From: Paul Troop <pault@gclaw.co.uk>
Sent: 24 November 2021 13:45
To: Caroline Ford; Planning
Cc: White, Joy - Communities; bicesterbug
Subject: 21/03177/F Howes Lane, Bicester Comments

Paul Troop
On behalf of Bicester Bike Users' Group

Drawing Title:
CYCLE SHELTER DETAILS

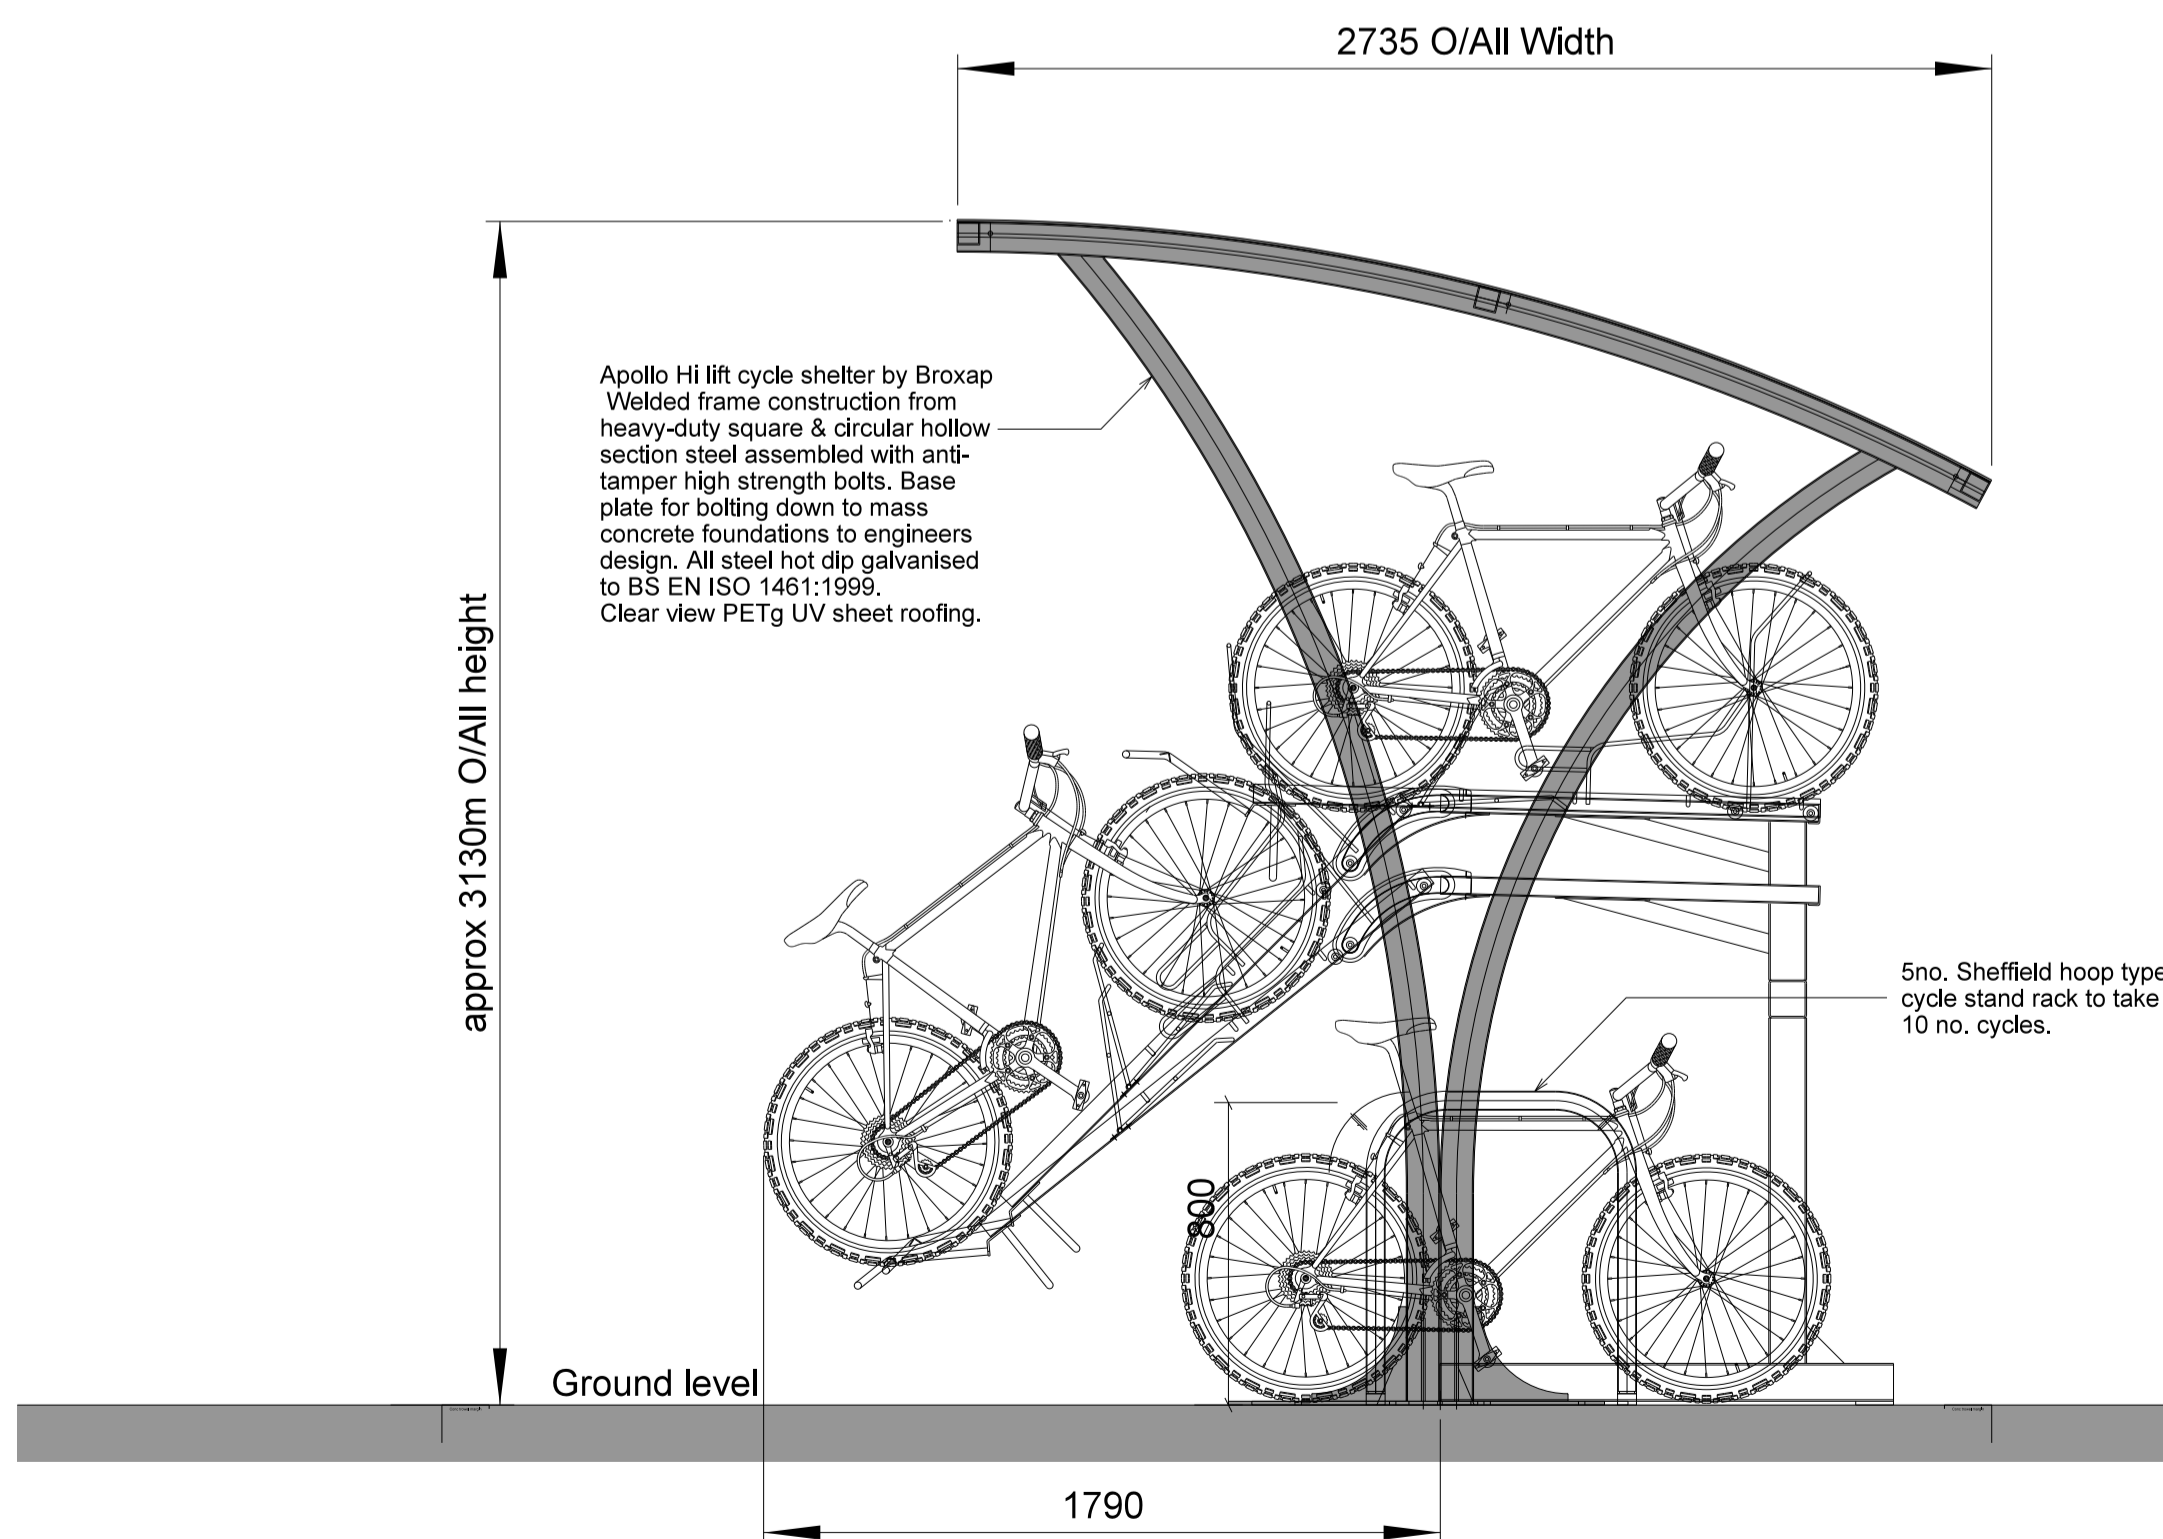
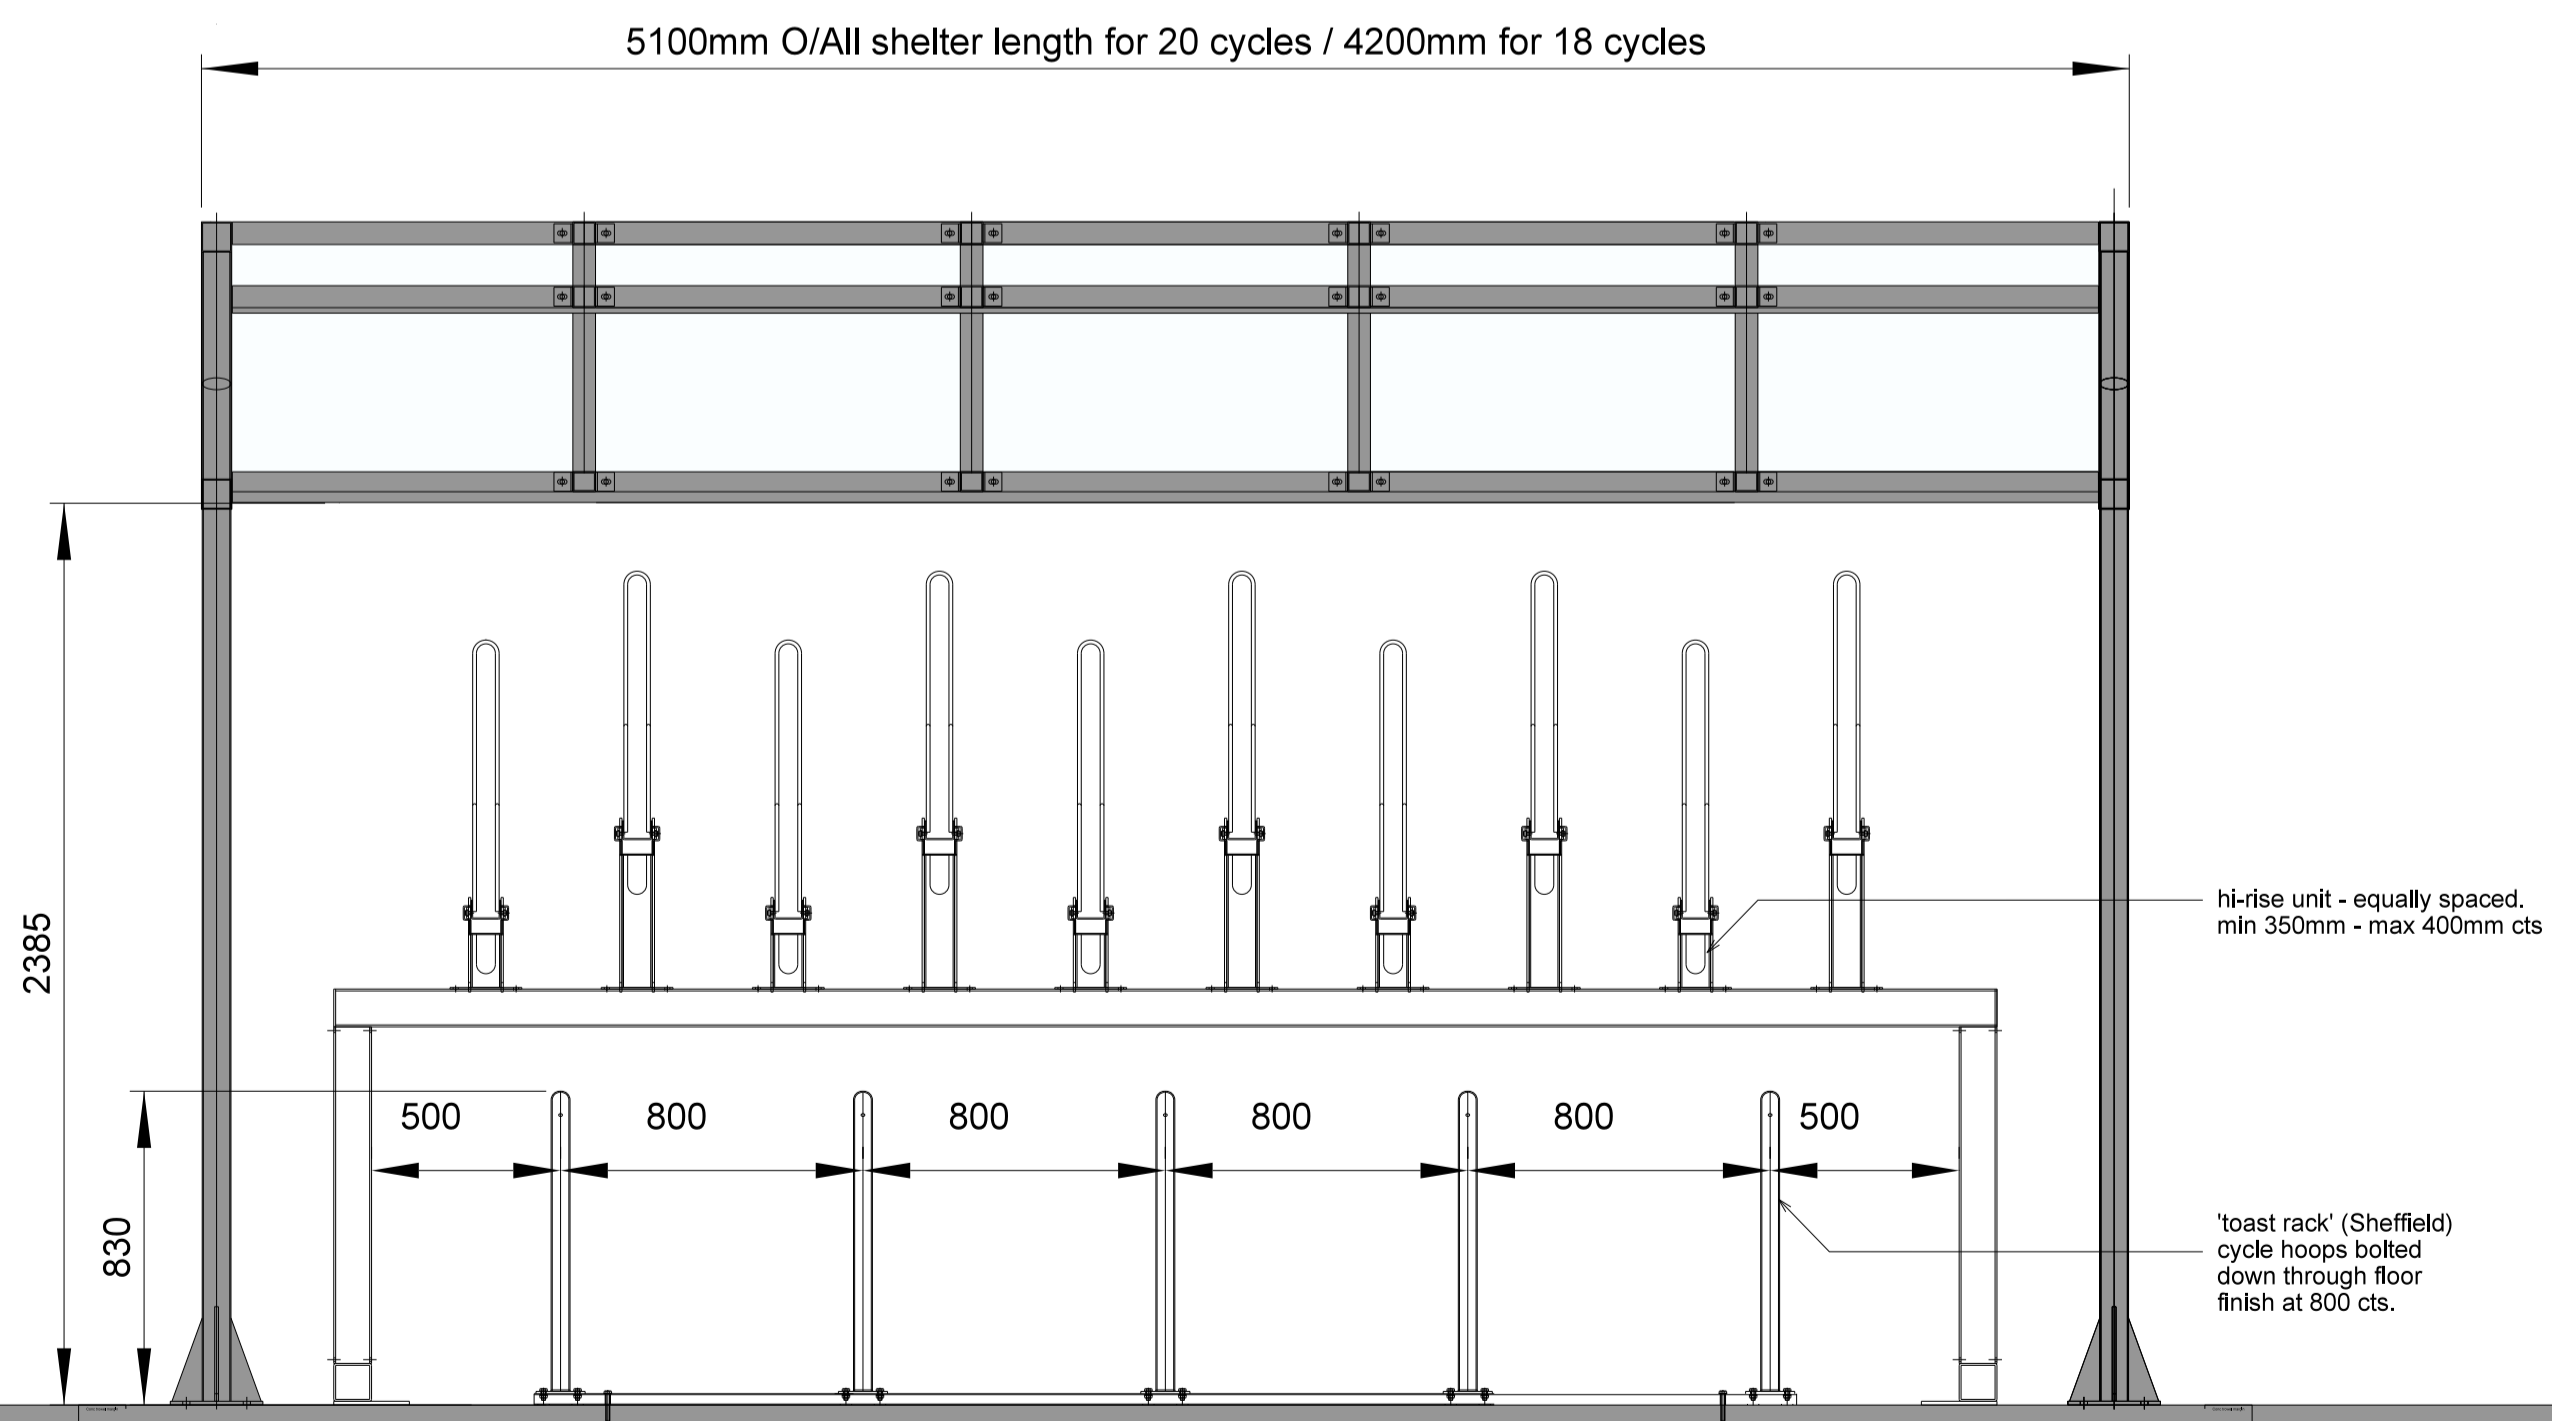
8. The applicant has correctly indicated cycle storage, but this appears to be below that which would be required according to LTN 1/20 and in the wrong locations. Furthermore, given the significant increases in e-bike sales, and corresponding increase in value of such bikes, the cycle storage should be immediately adjacent to the entrance to each unit where it can be observed passively and provide reassurance to the owners and users of such bikes that their valuable possessions are not at risk of being stolen.
